Yass Valley Wind Farm

Landscape and Visual Impact Assessment - Response to Secretary's Environmental Assessment Report

0092376 RPT3 Final

March 2015

Viewpoint C41a

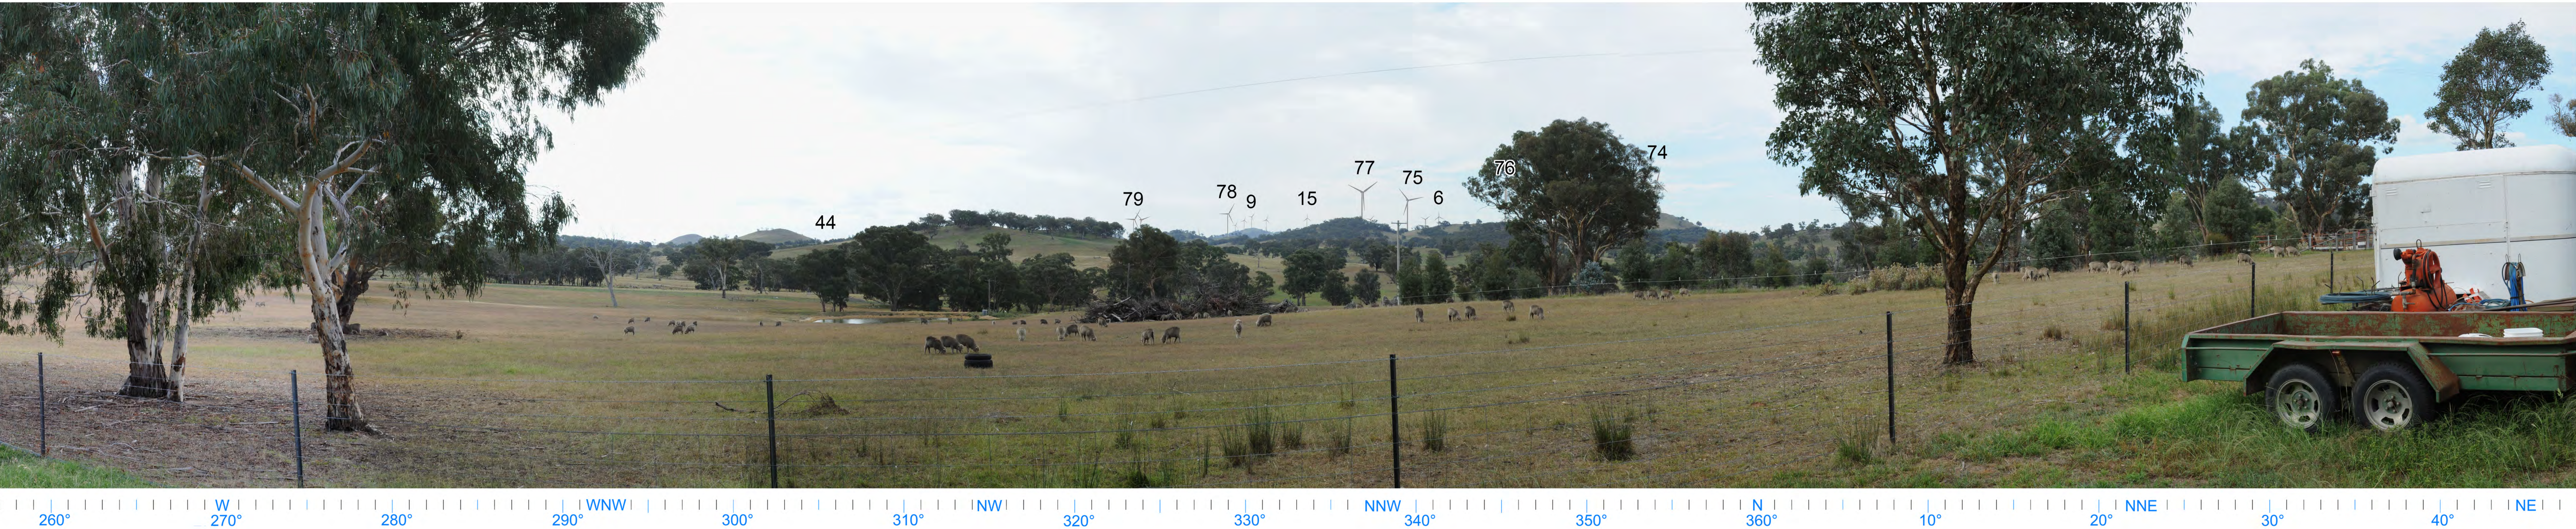
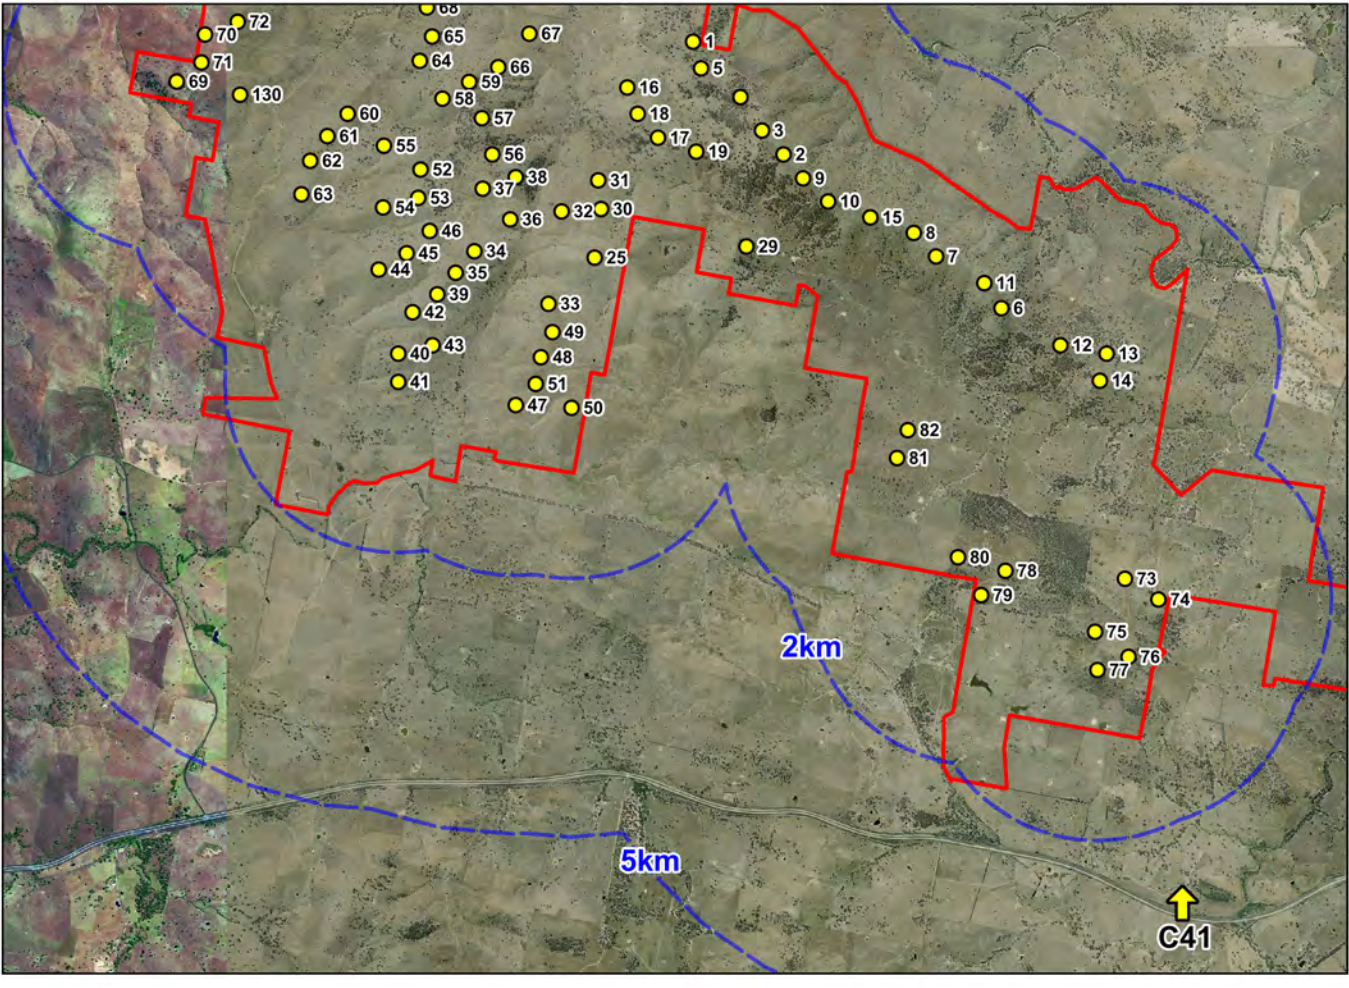
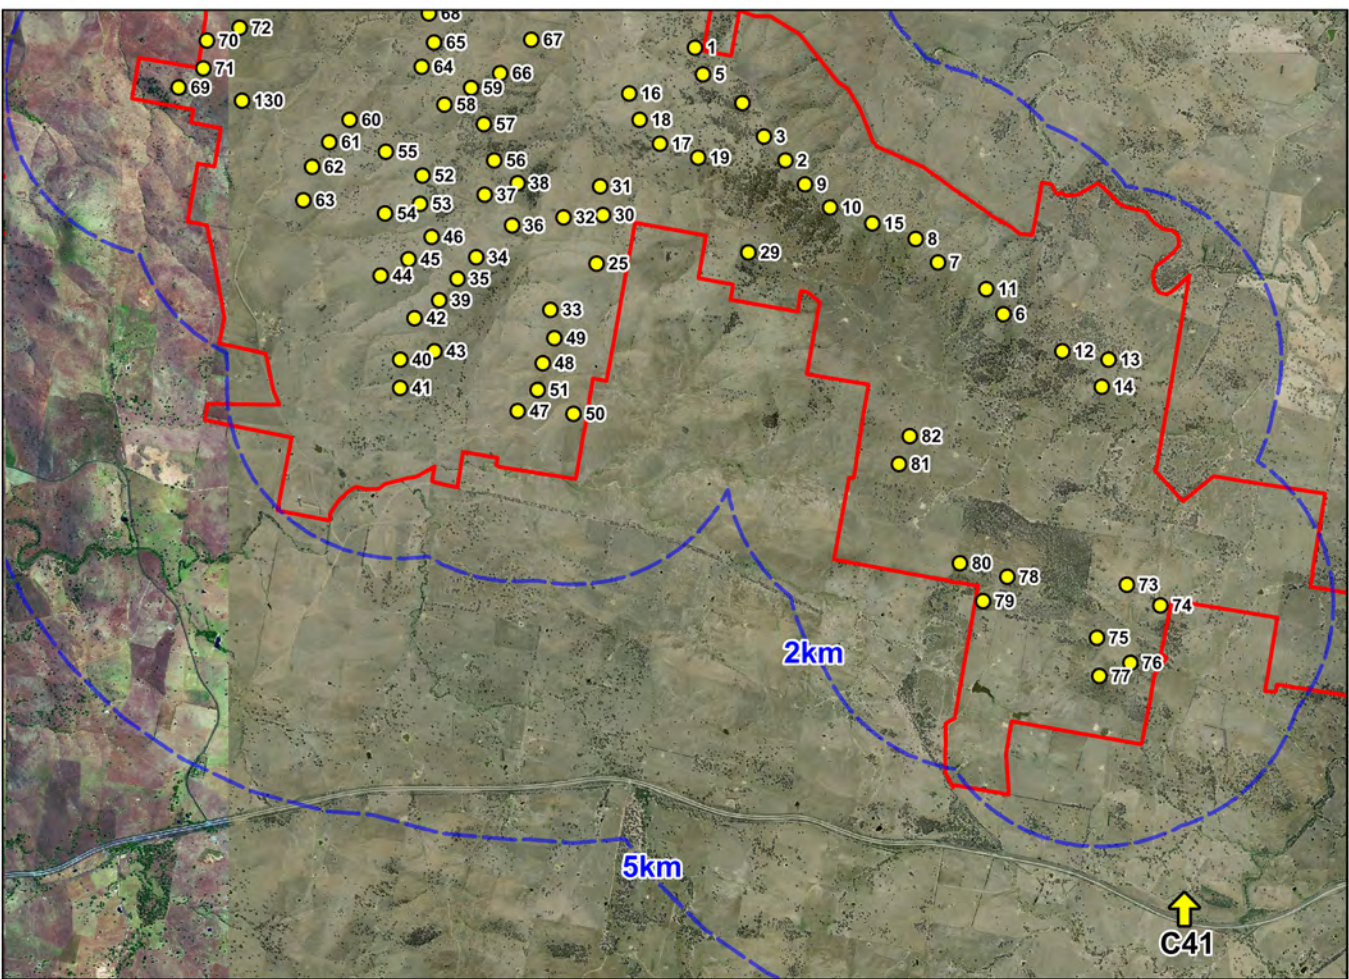
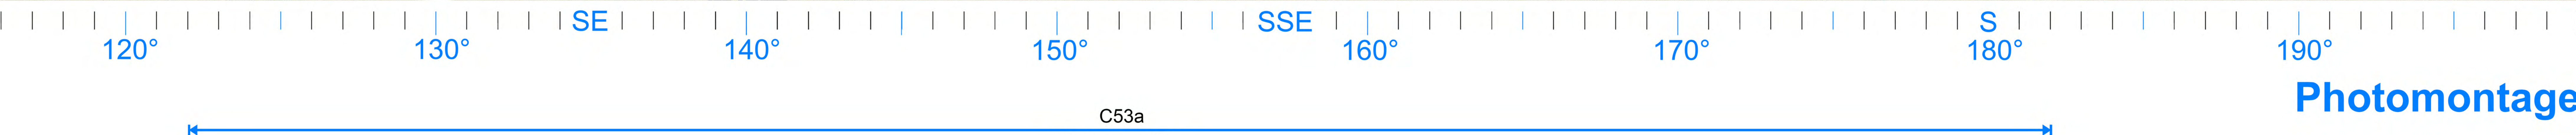
- *there is a lack of photomontages for an area along the Hume Highway to the west of Bookham, where there is a group of non-associated houses, including C75, C06, C08, C60 and C41, which are also identified as being some of the most affected receivers;*

Revised photomontages based on the Amended Layout have been prepared and are appended in Annex A. These are perceptually accurate when printed at A0. It is noted that the RLA Report has no alternative photomontages depicting a better or more perceptually accurate image. The claim that these are not accurate is unsubstantiated.
